Greenwich Community Association Inc Submission to The NSW Department of Planning and Environment

Rezoning of Crows Nest Sydney Metro Site

Due Date for Submissions 3 December 2018

2.3 General Arrangement Sections and Elevations
2.3.1 Massing Elevations

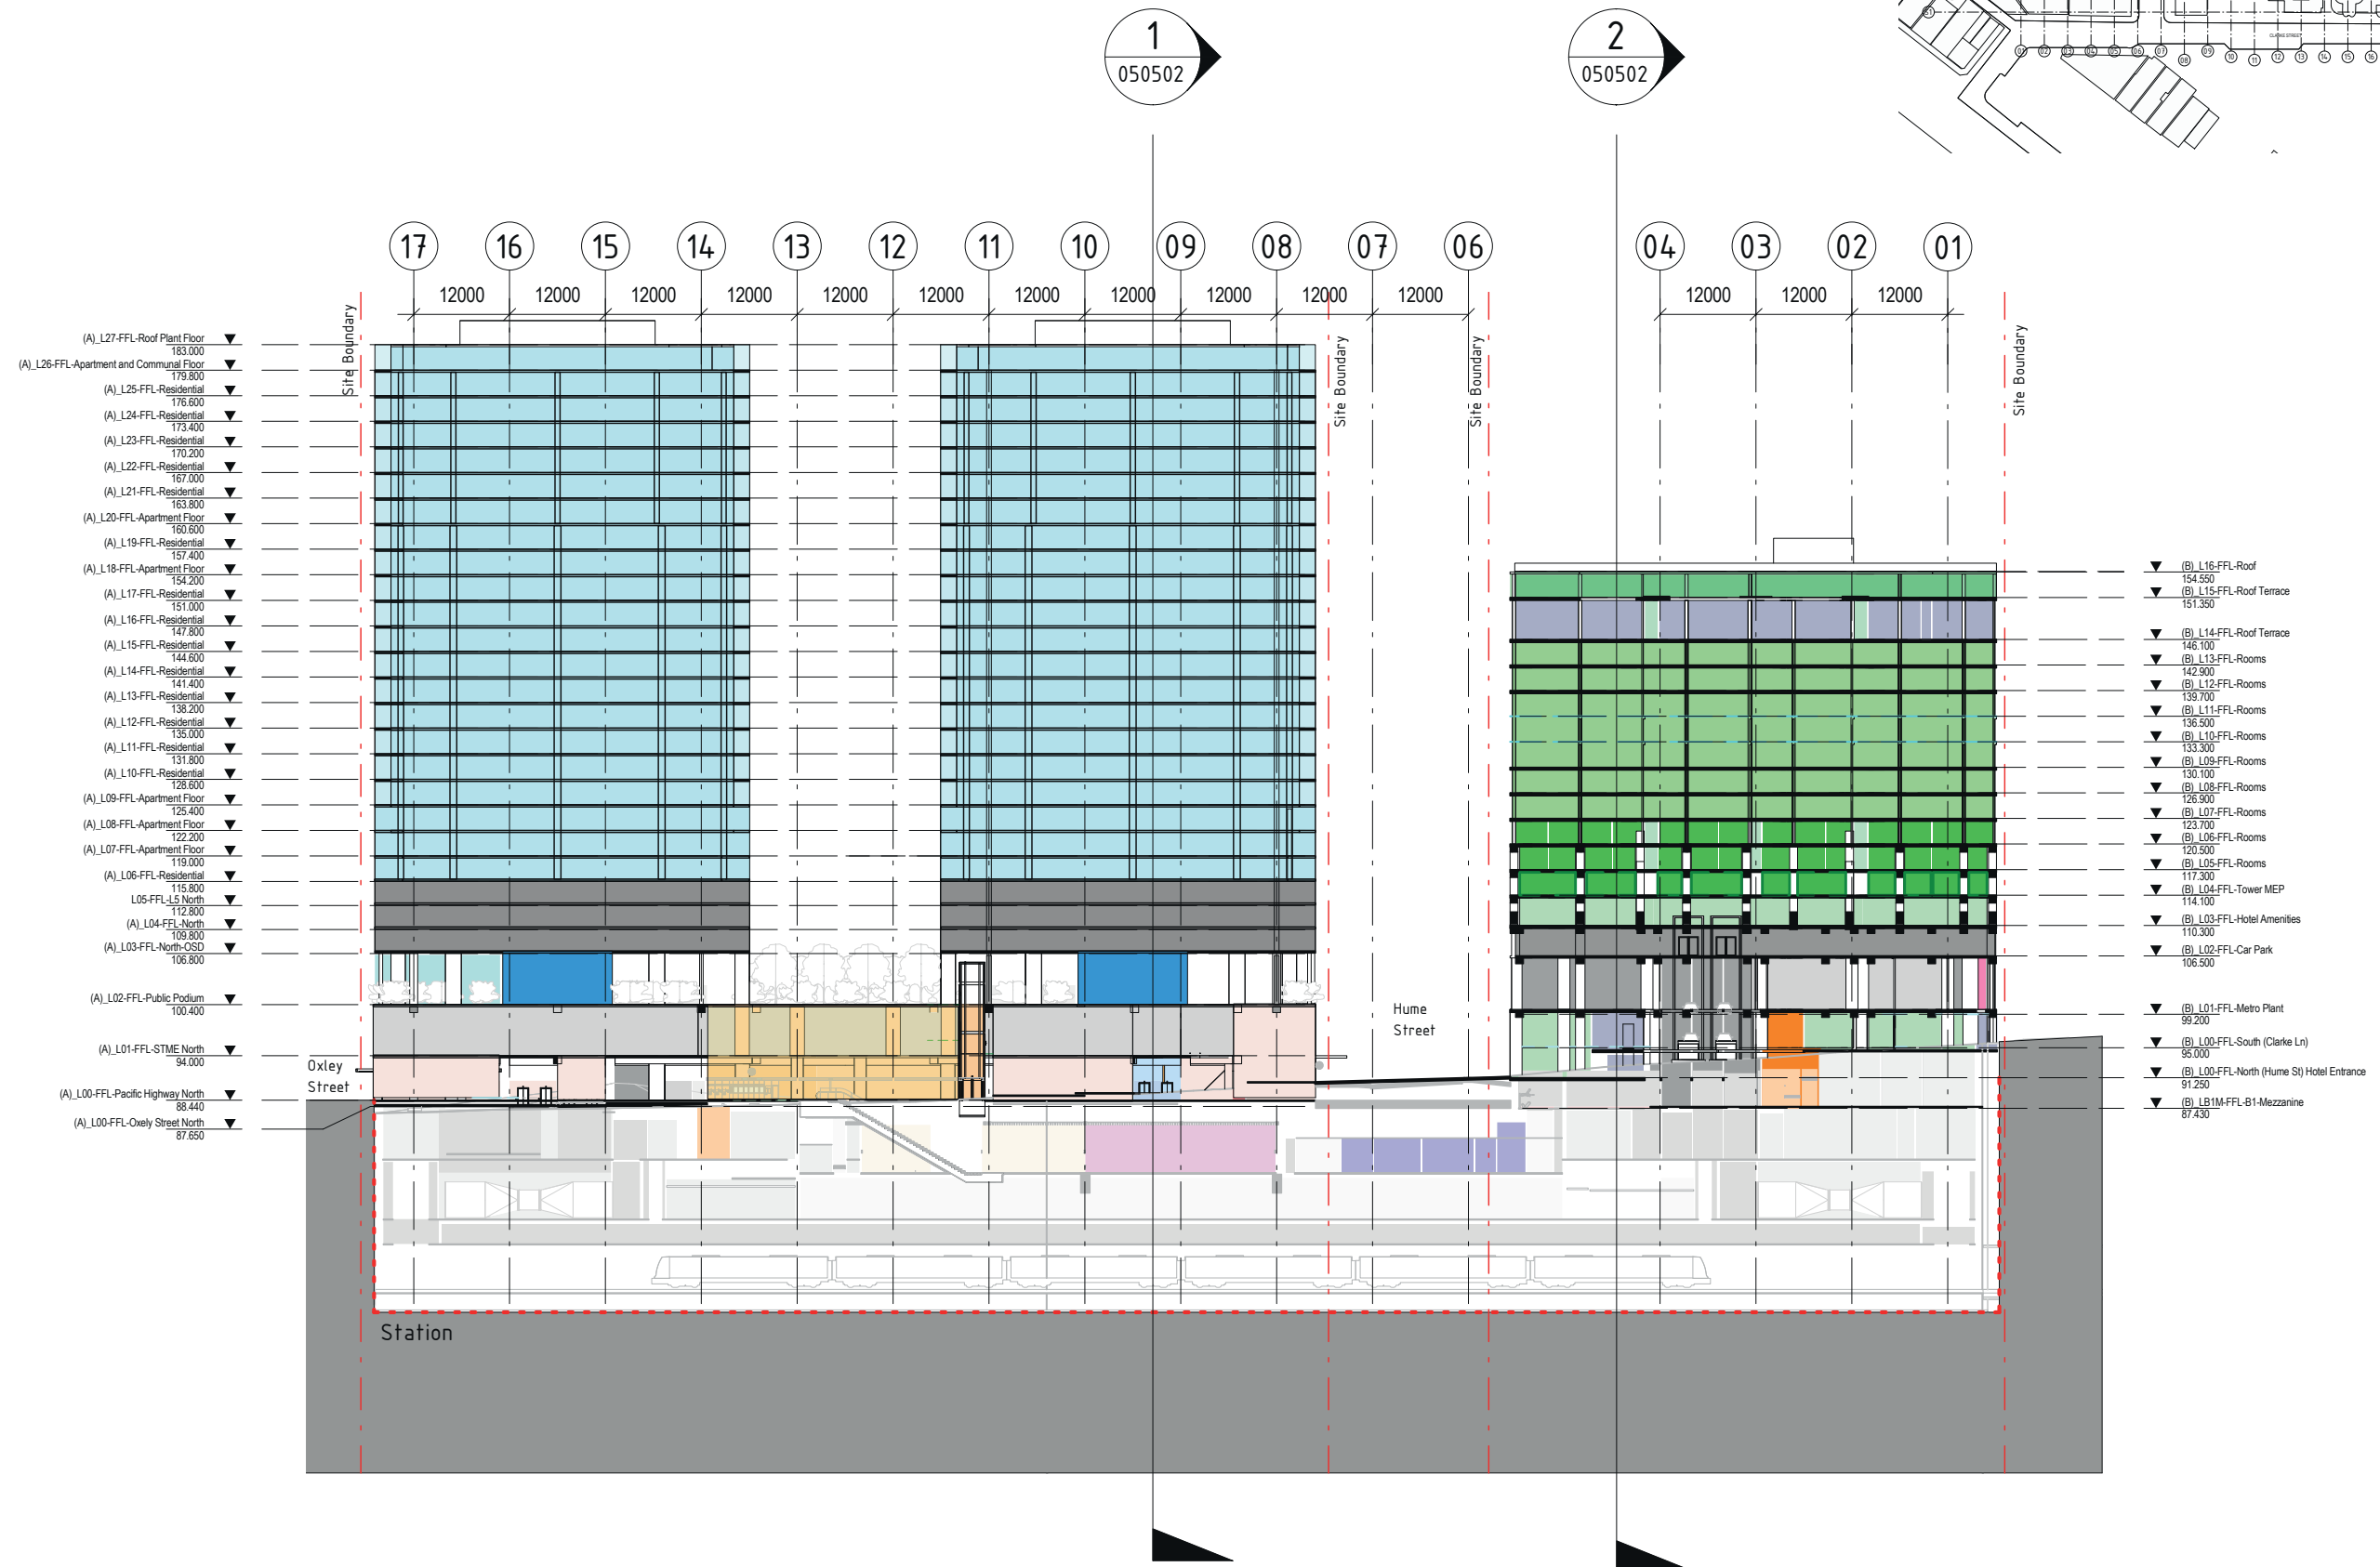
Increasing the heights results in a very bulky development which is evident from the illustrations in Metro Detailed Design Study. It will overlook and overpower other sites in the vicinity especially those to the east towards Willoughby Road.

The increased heights of the towers will also cause substantial overshadowing of residential areas to the west of the Pacific Highway. This is shown clearly in the Design Testing section of the Metro Detailed Design Study which notes overshadowing all morning up to 12:00md in mid-winter.
